Planning Act 2008 – Section 88 and the Infrastructure Planning (Examination Procedure) Rules 2010 – Deadline 5: Post Hearing submission of oral case for Issue Specific Hearing 7 (Biodiversity and Ecology), Part 1 and 2.

Application by NNB Generation Company (SZC) Limited for an Order Granting Development Consent for the Sizewell C Project

Appendix A: Environment Agency summary of oral case for ISH7 – Part 1: Biodiversity and Ecology

DRAWING TITLE:
MAIN DEVELOPMENT SITE
KEY PLAN
RULE 17 REQUEST FOR FURTHER INFORMATION

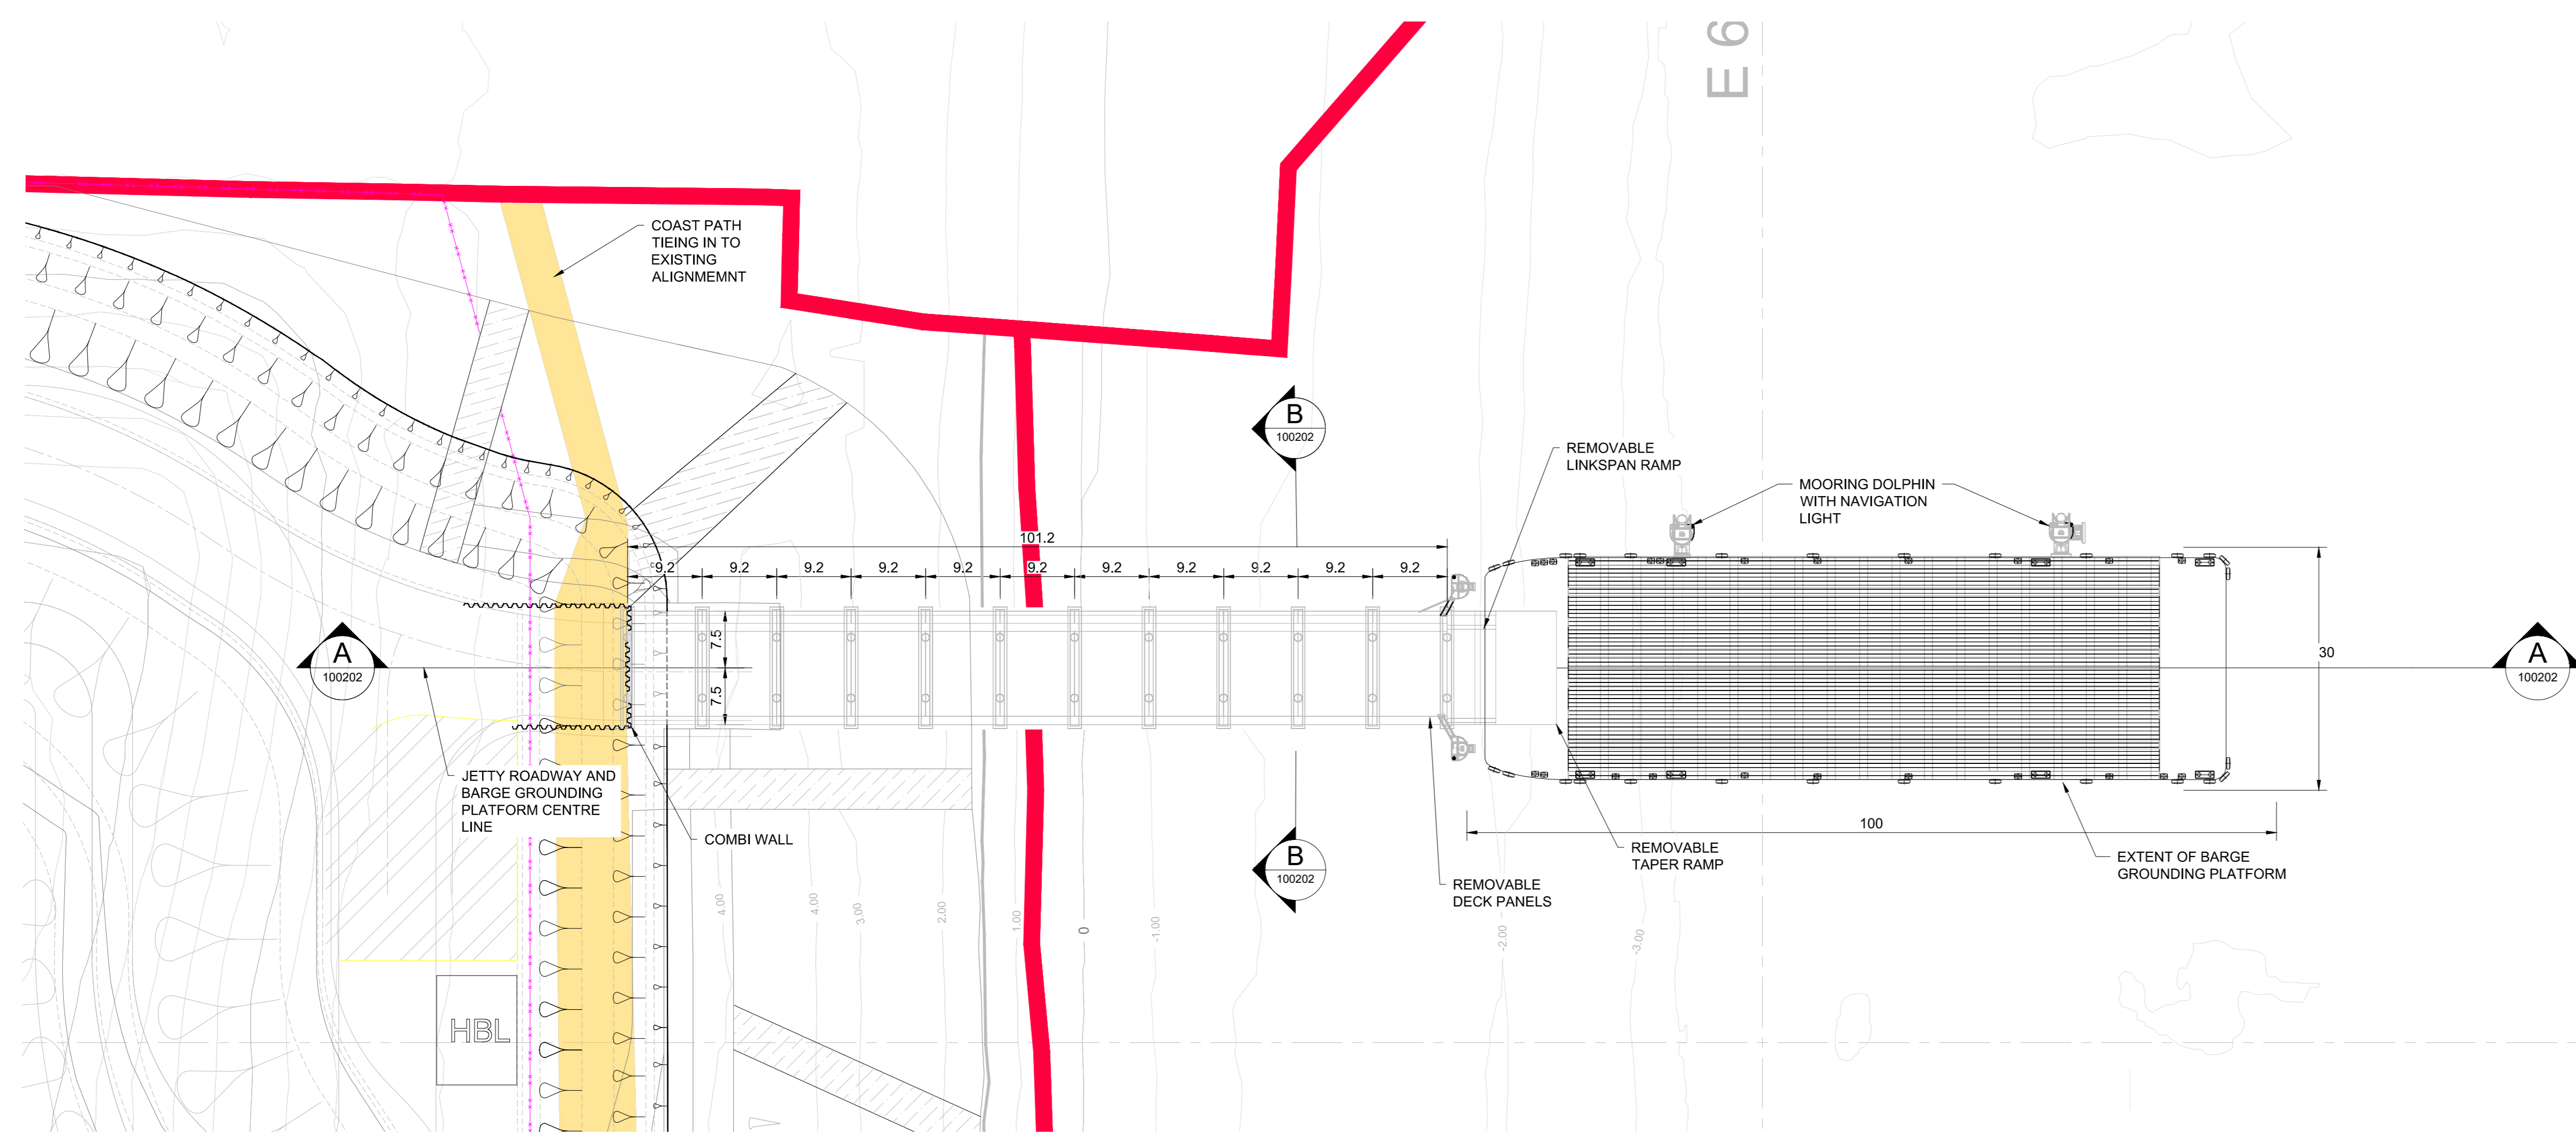
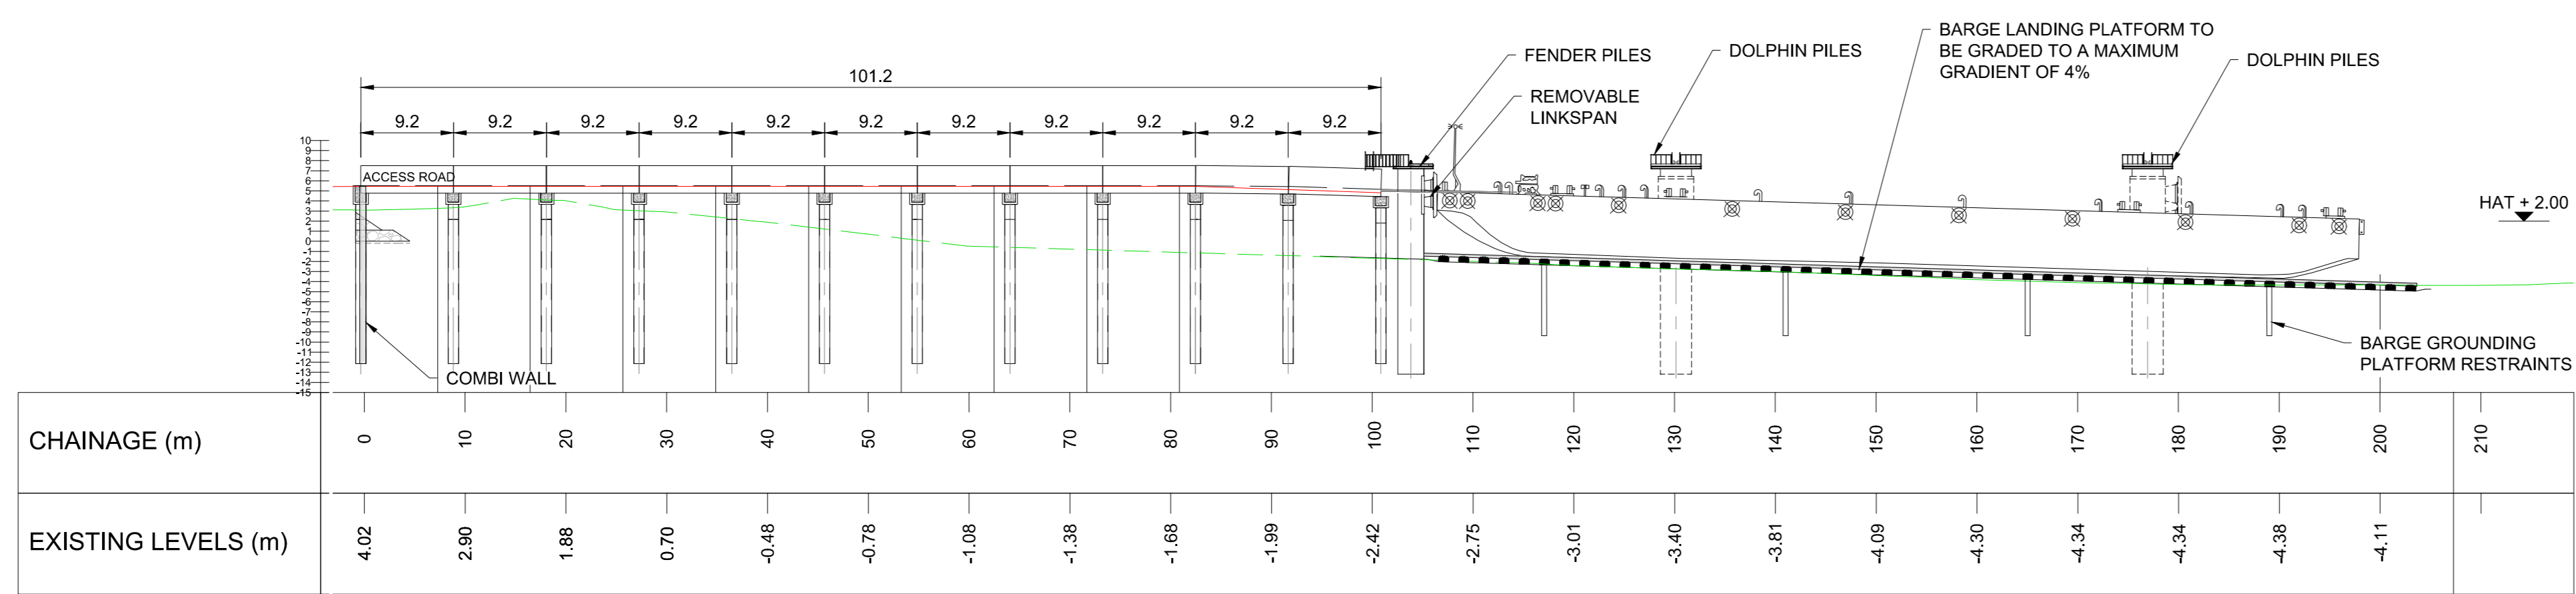
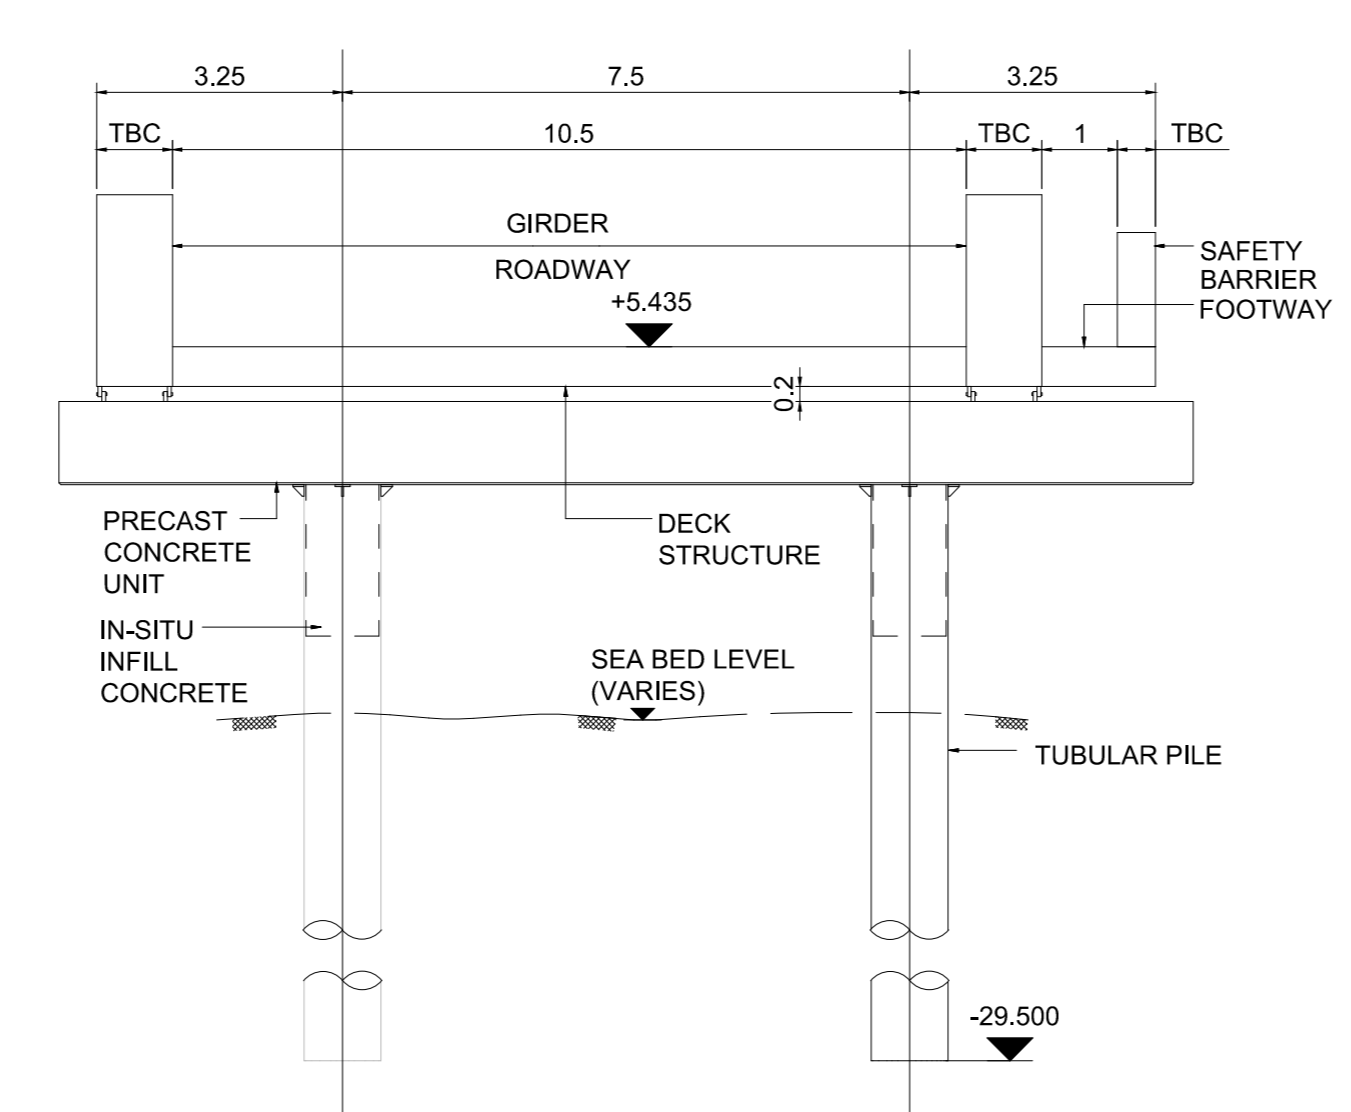
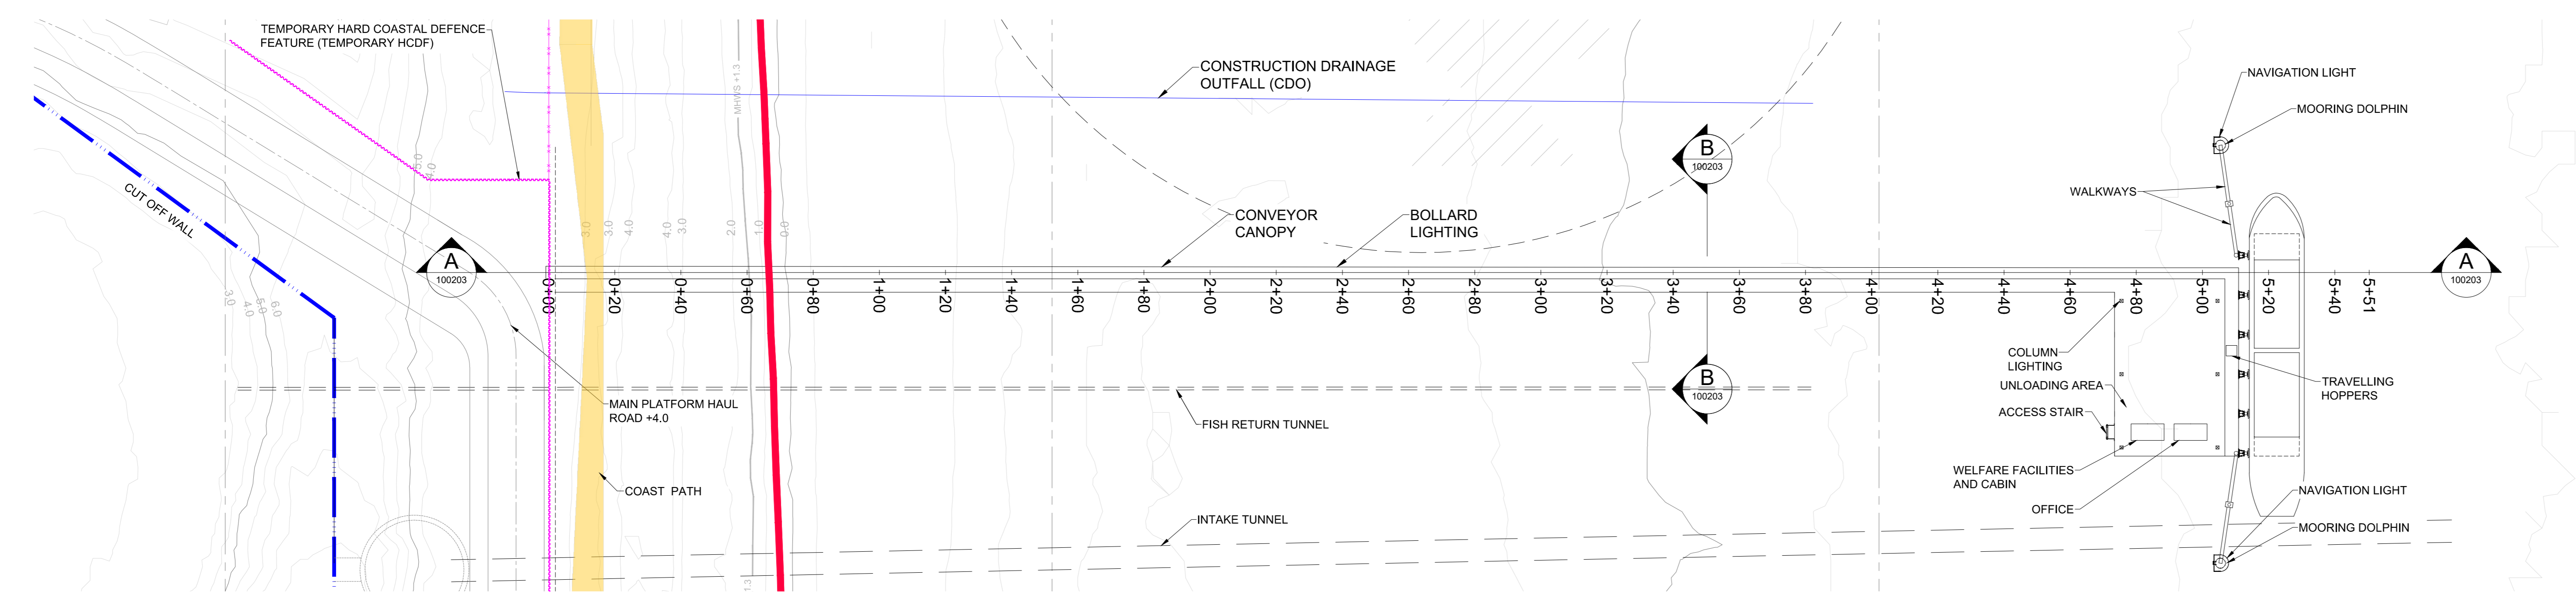
i. the SSSI crossing	<p>SSSI crossing:</p> <p>The current proposed design of the SSSI crossing would prevent the upstream and downstream migration of numerous polarotactic invertebrate species (which navigate using polarized light reflected from the water's surface) either side of the crossing approximately halfway along the river, and its associated SSSI designated habitat. This will lead to fragmentation of sensitive habitats and the isolation of species populations which could lead to a deterioration under the Water Environment Regulations 2017 (WFD) and would require a regulation 19 exemption under those regulations. It could also prevent the movement of fish along the watercourse.</p> <p>The proposed design optimisation of increasing the soffit height of the crossing to >6m and reducing the width of the crossing to 15m after the construction period, as described by the Applicant in the response to our written representations is welcome. We await submission of the detailed designs and timeframes for each phase of the crossing at deadline 5. We will then determine if the risk of deterioration to invertebrates has been reduced to an acceptable level.</p> <p>The triple span bridge design remains our preferred option as it would further reduce impacts to the ecology of the area including invertebrates, and it would have the minimal land take from the SSSI.</p>
